Recommendation Report for Planning Permission for Works or Extension to a Dwelling

REF NO: AL/97/19/HH

LOCATION: Mrs T
Nyton Road
Westergate
PO20 3UN

PROPOSAL: New wooden 5-bar gate and support posts and gate to rear.

EXISTING GROUND FLOOR PLAN

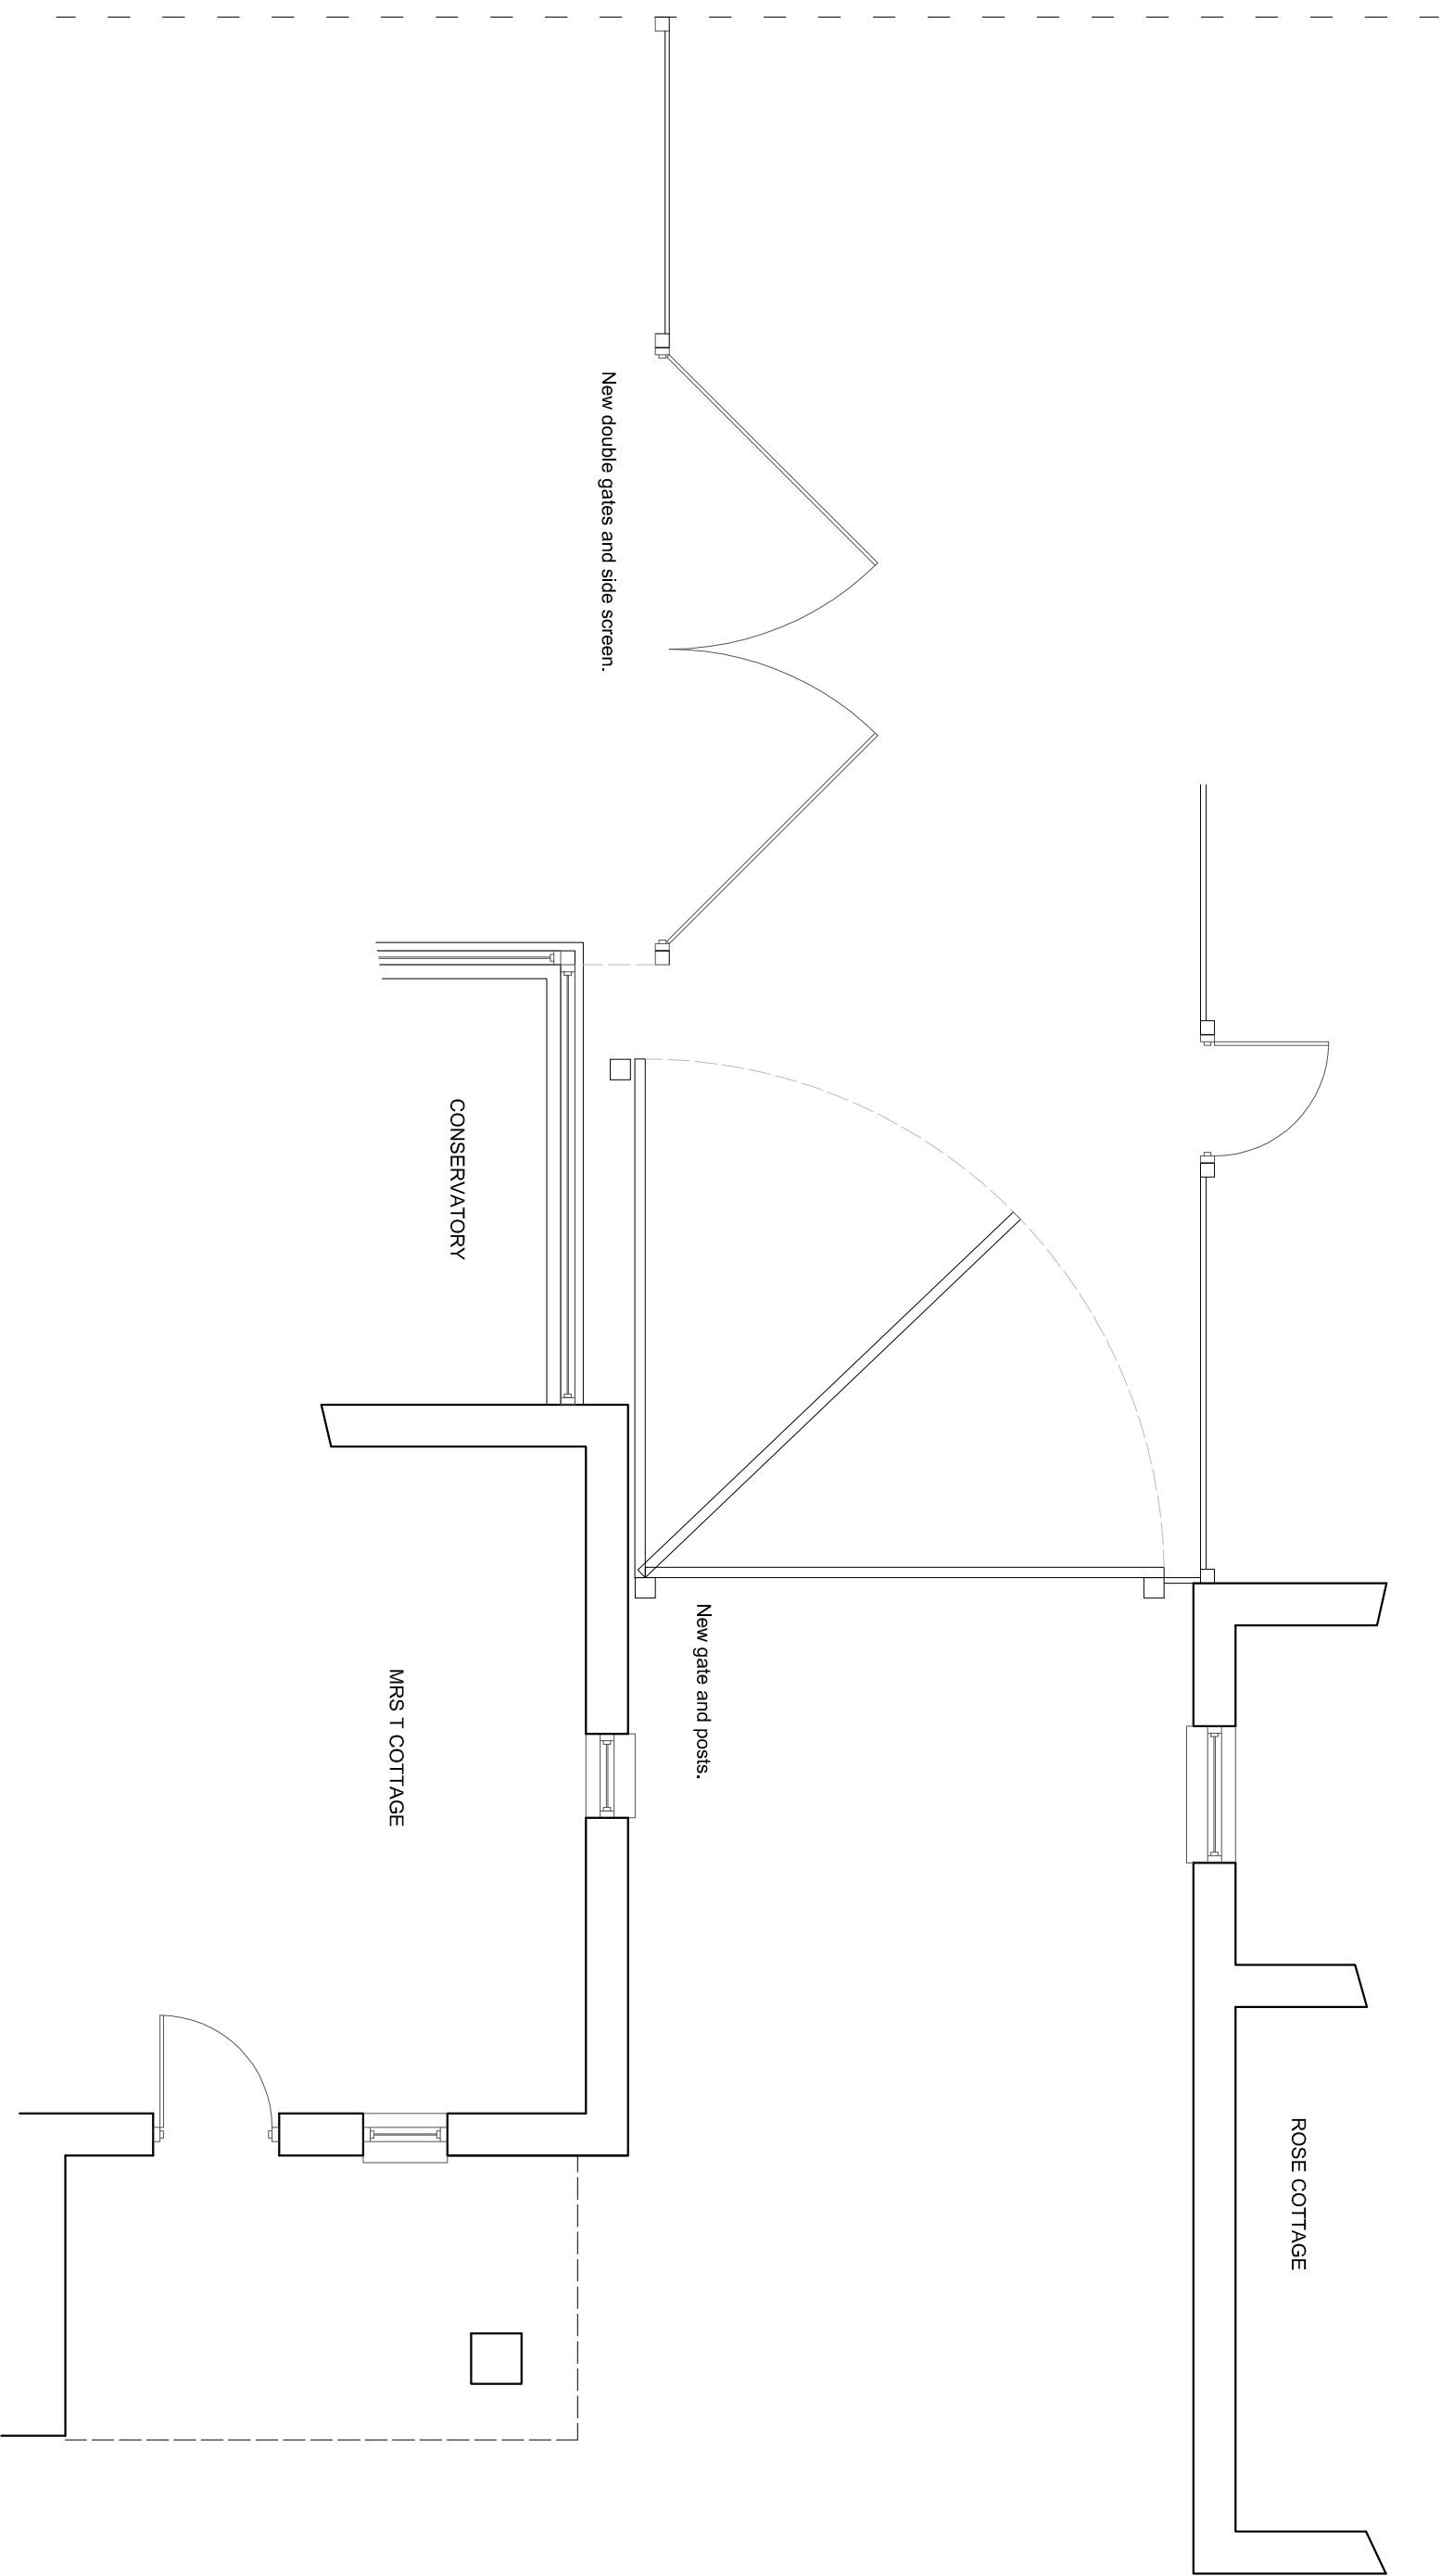
The application proposes two sets of gates. Double gates and a slide screen is located to the rear of the property and as such is not visible from the wider area. The 2nd gate is located to the eastern side of the dwelling and is visible from the street scene, however is set back approximately 10.5m from the front boundary.

The gate to the front has a width of approximately 4m and attaches to neighbouring property to the east which is Grade II Listed.

It is a 5 bar gate to a height of approximately 1.2m with 1.5m posts either side. With it set back from the street scene at a modest height, it is not considered to appear unduly dominant or out of character. Due to the design and size of the gates, they are not considered to adversely impact upon the visual appearance of the area and accord with D DM1 and D DM4 of the Arun Local Plan.

EXISTING FRONT ELEVATION

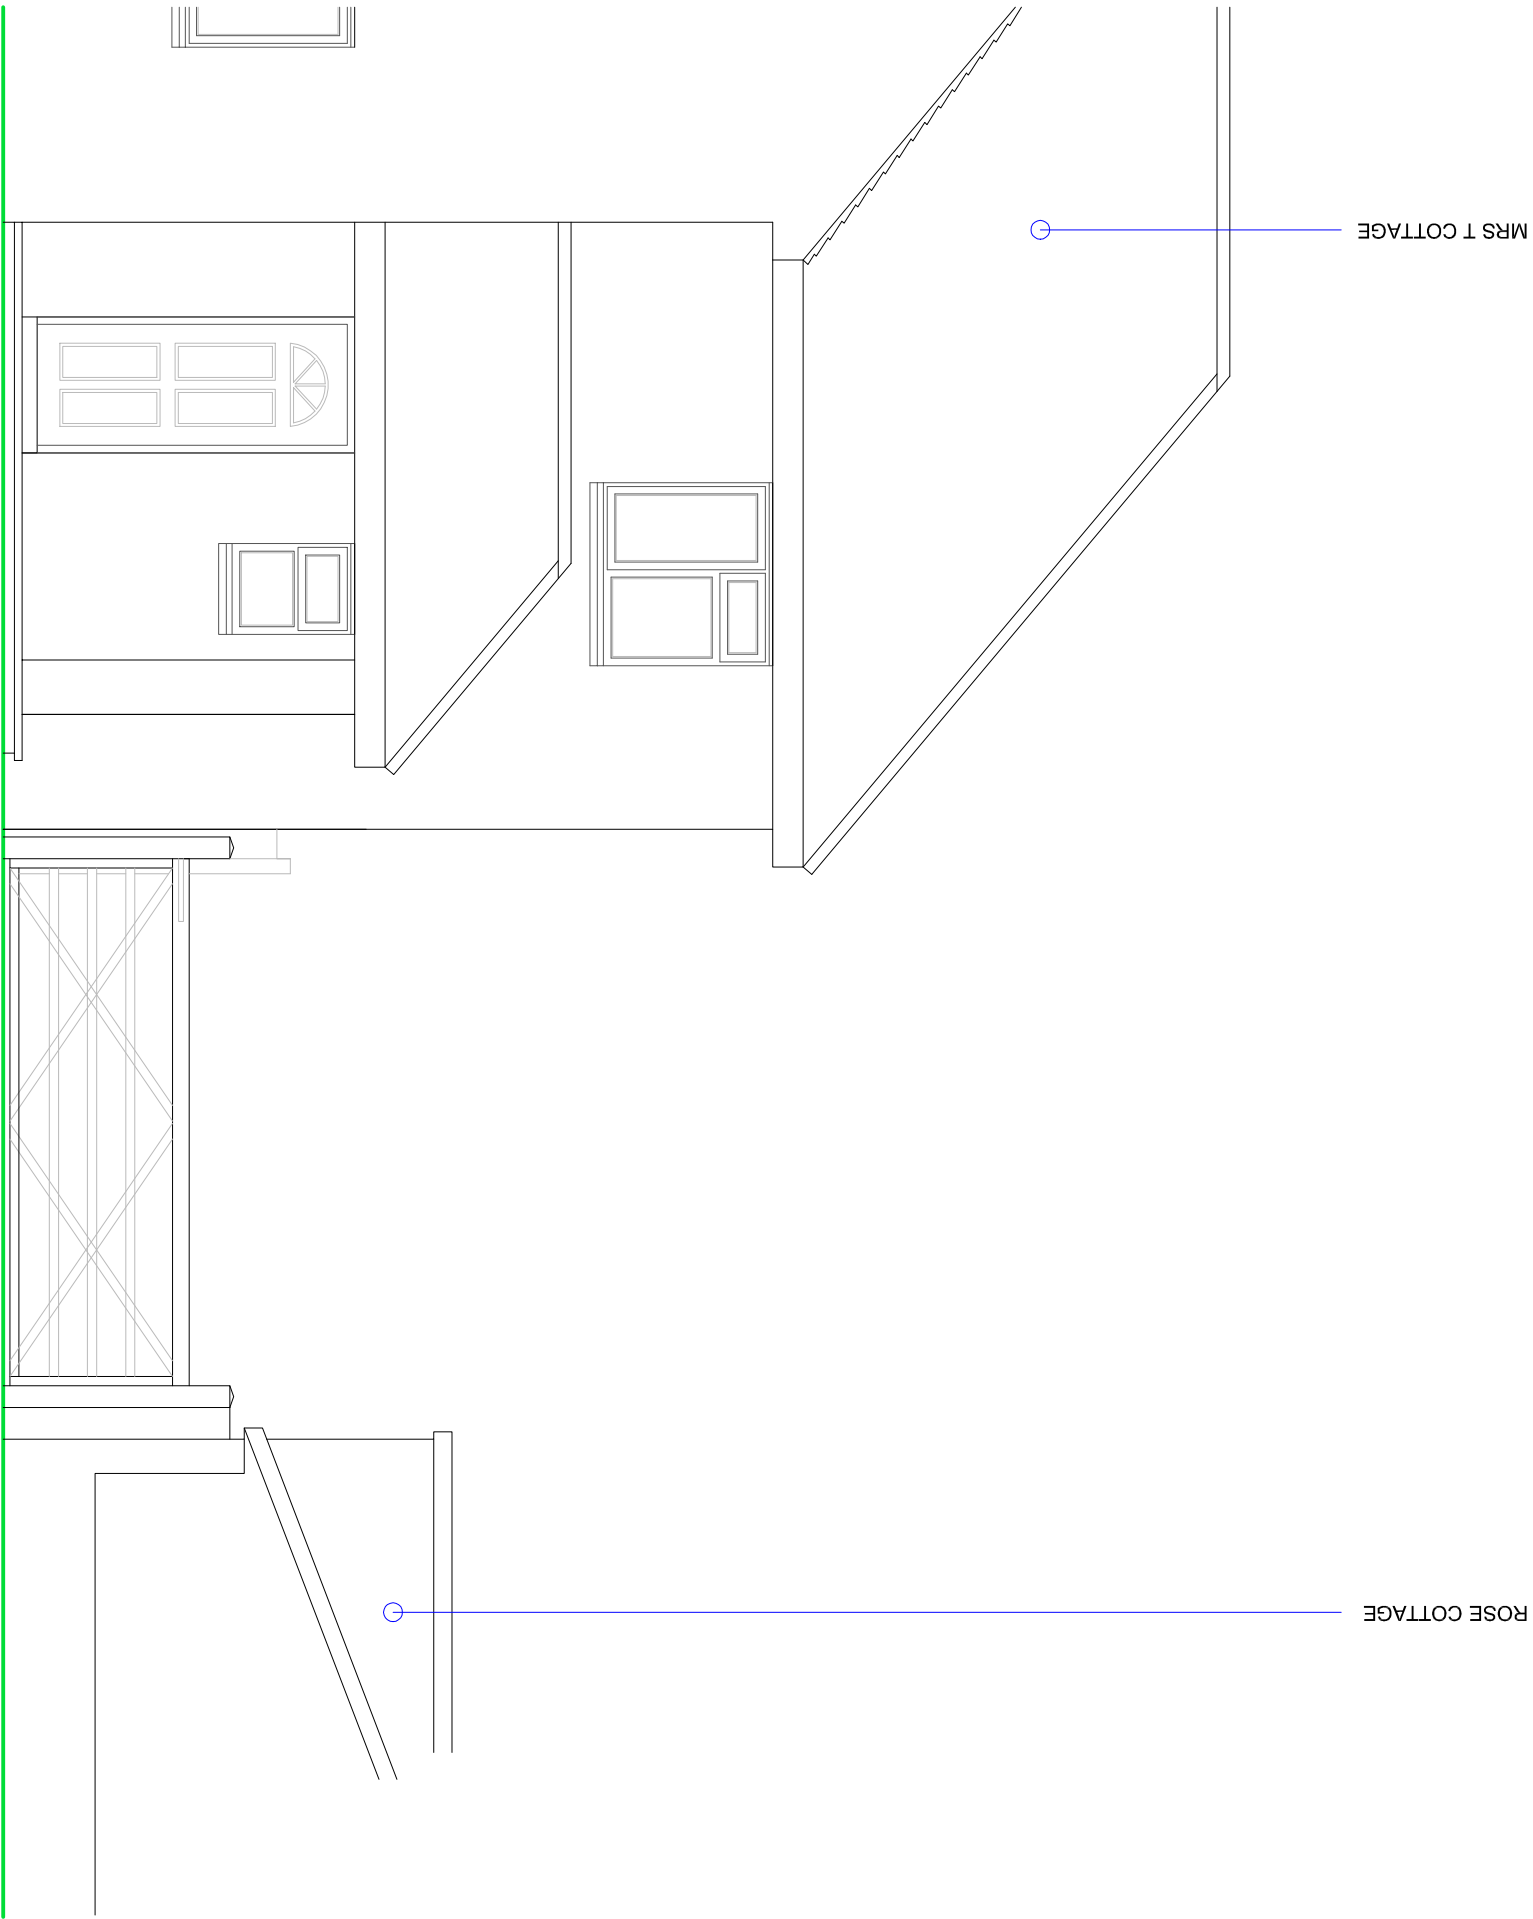
Whilst the property itself is not listed, it adjoins a listed building (Rose Cottage). The gate is simple in appearance and as a result of its design is considered to reflect the rural character of the listed building. Para 190 of the NPPF requires the LPA to consider to significance of the impact upon the heritage asset. As a result of the scale and design, it is not considered to harm the significance of the listed building and accord with HER DM1 of the Arun Local Plan.

The 5 bar gate which fronts the road is around 1.2m in height and due to its siting at the side of the property does not adversely impact upon neighbouring amenity by way of overbearing, overshadowing or overlooking.

EXISTING SIDE ELEVATION

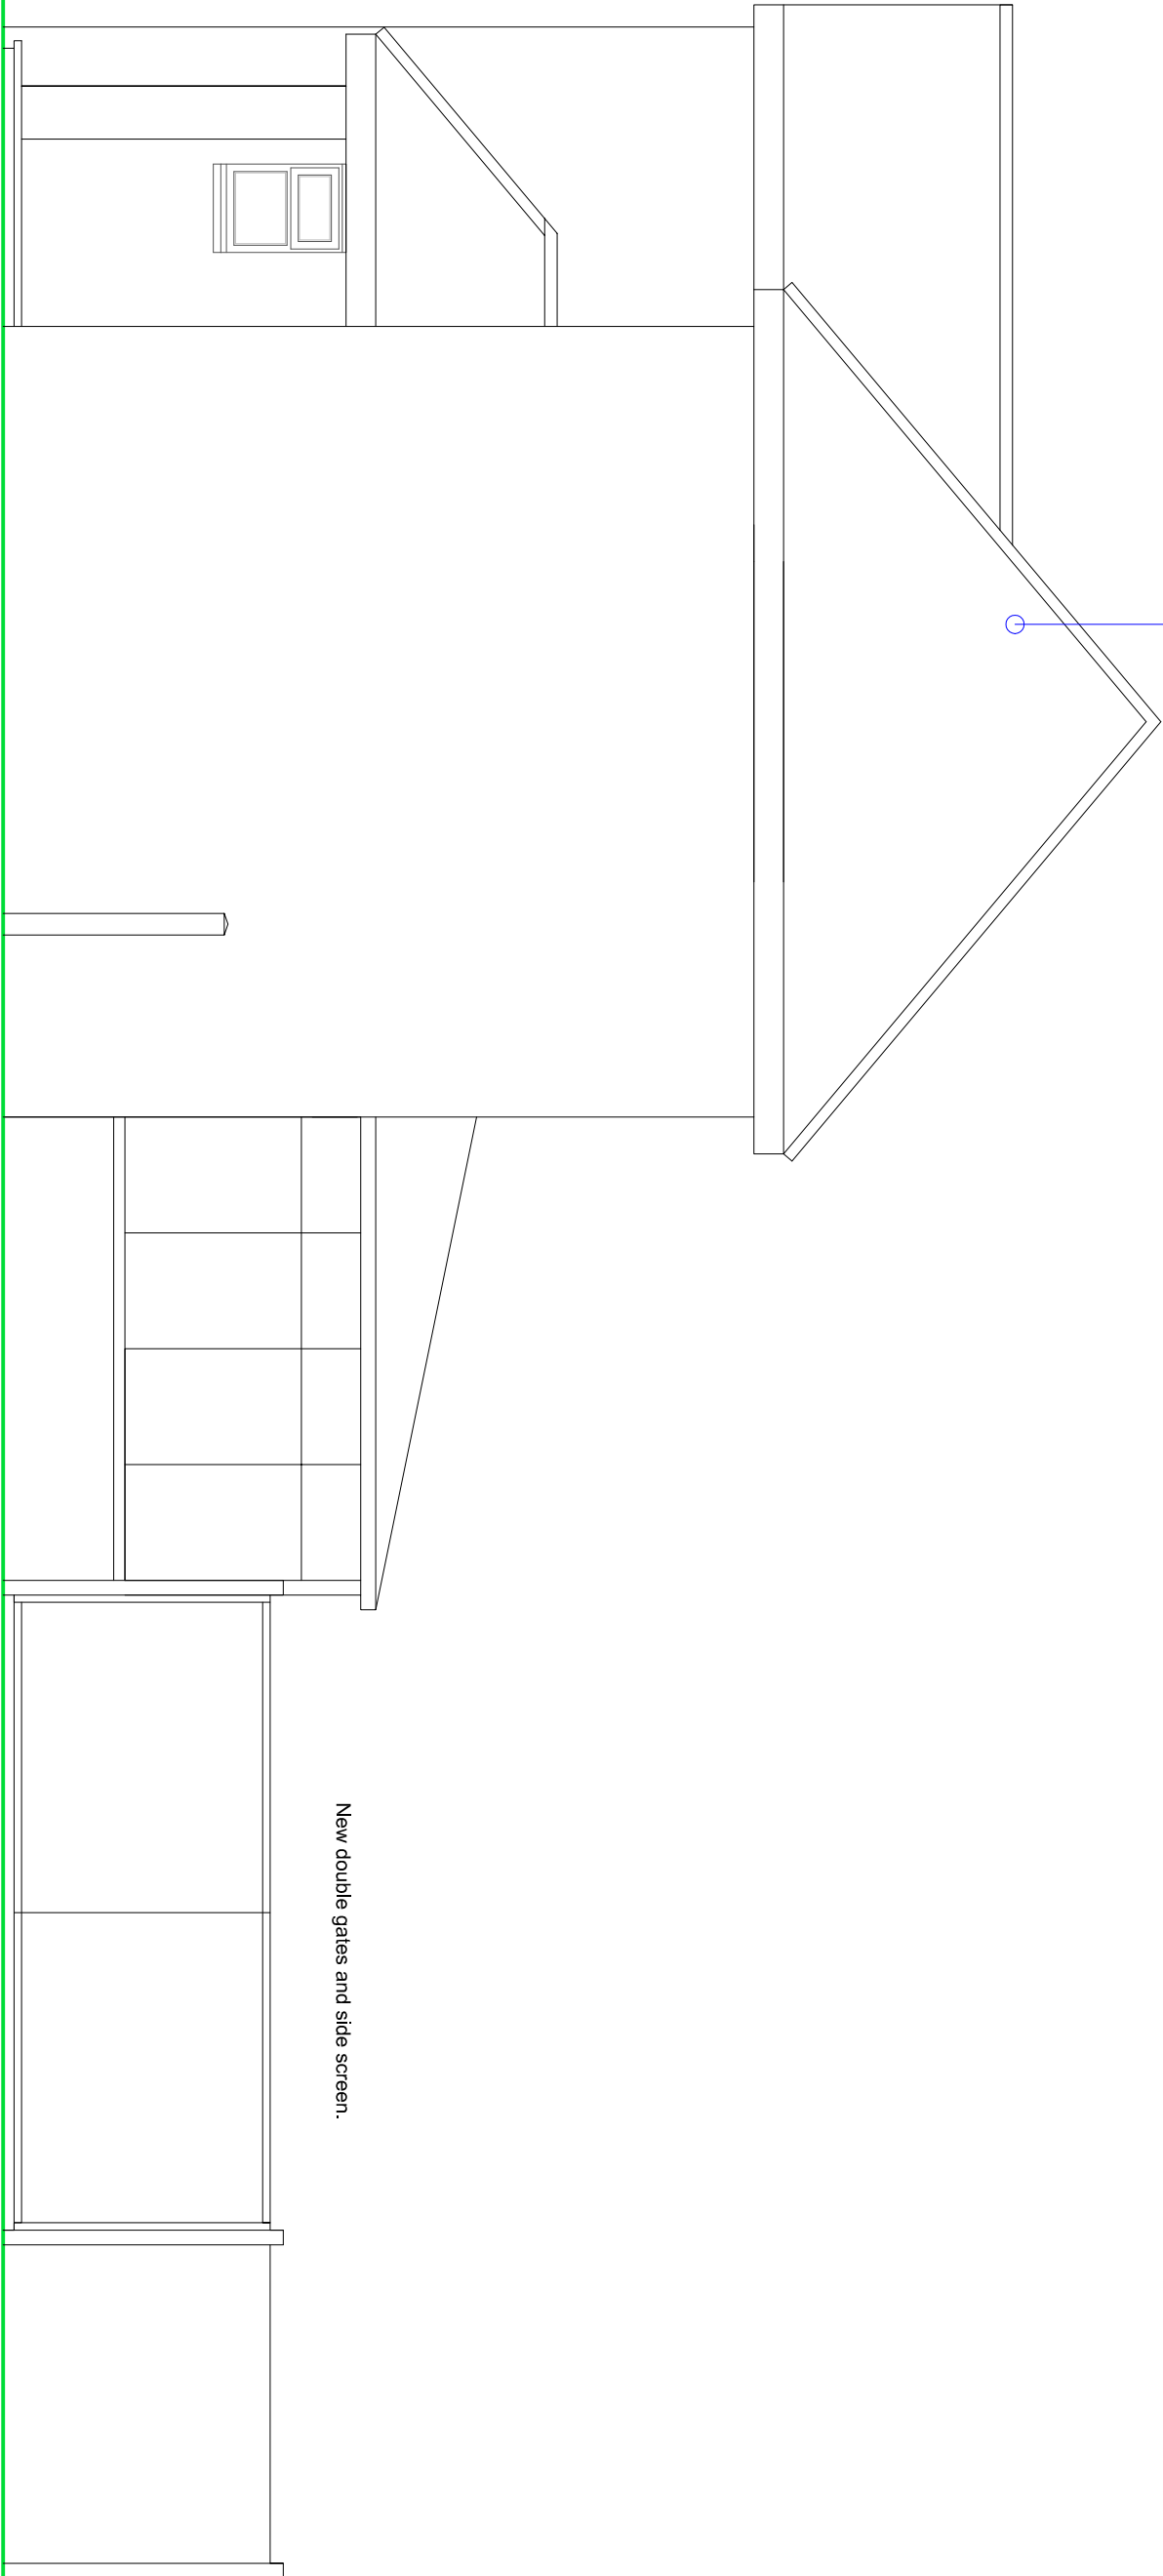
The fence and slide screen to the rear is approximately 1.8m in height and has a total width of 6.65m meeting with the rear boundary. A fence of this height would normally fall under permitted development, however rights have been removed due to it falling within the curtilage within the listed building. Again due

to the siting of the fence, it is sufficient distance away from both neighbouring properties and is not considered to result in adverse impacts.
